Application No.	2025/92438
Proposed Development:	Temporary use of vacant land as TRU staff car park and associated works (within a Conservation Area)
Location:	Land off, Fitzwilliam Street, Huddersfield
OS Map Reference	SE 414045.5303 416926.0773
Applicant/Agent:	Network Rail
Class:	Small Major Developments
Site Area (sq. m):	9236.5

**Consultation Response from KC,  
Trees**

**2025/92438 Land off, Fitzwilliam Street, Huddersfield**

**Temporary use of vacant land as TRU staff car park and associated works (within a  
Conservation Area)**

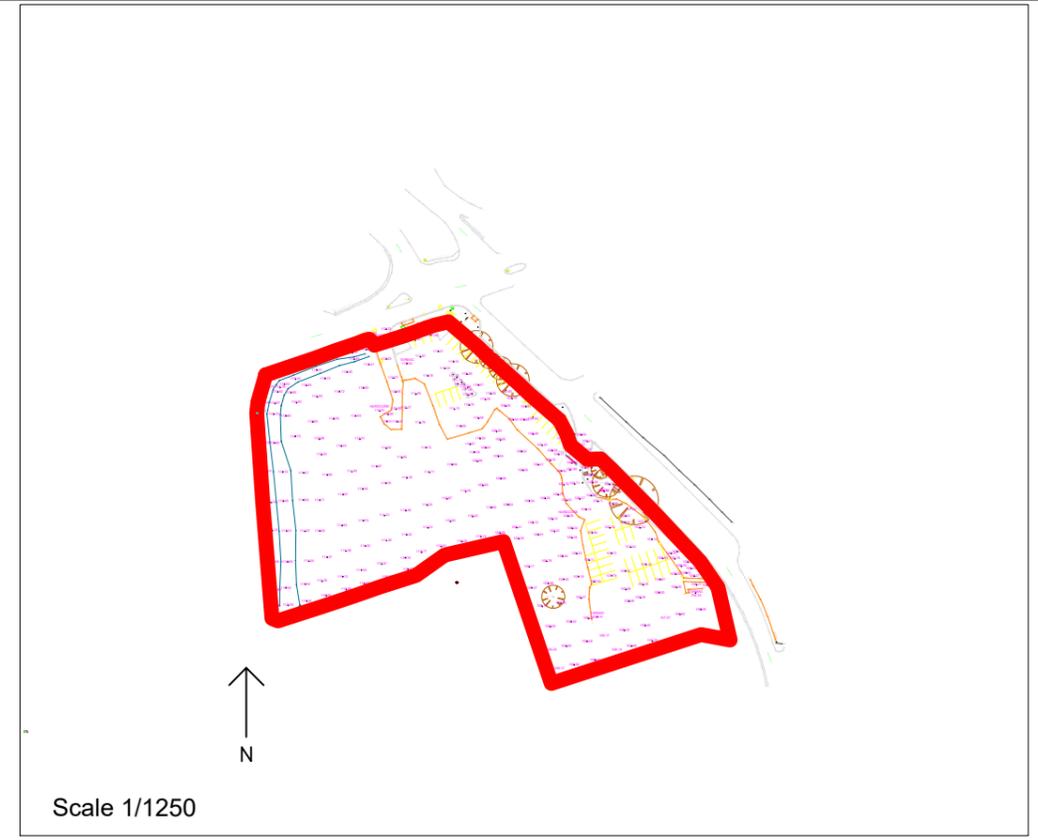
The eastern boundary of the site looks to be lined with a mix of mature/early mature and semi mature trees. The proposed site layout appears to show all trees as removed which is unacceptable due to their highly visible location adjacent New North Road, a busy and well used road.

No tree information has been submitted with the application, so it is impossible to make an accurate assessment of the quality of trees and therefore their retention category.

There is a holding objection until a BS5837 Arboricultural Impact Assessment is submitted which shows the level of impact the proposals will have on the trees. There is also likely to be a need for an Arboricultural Method Statement along side this which shows how retained trees will be protected during construction.
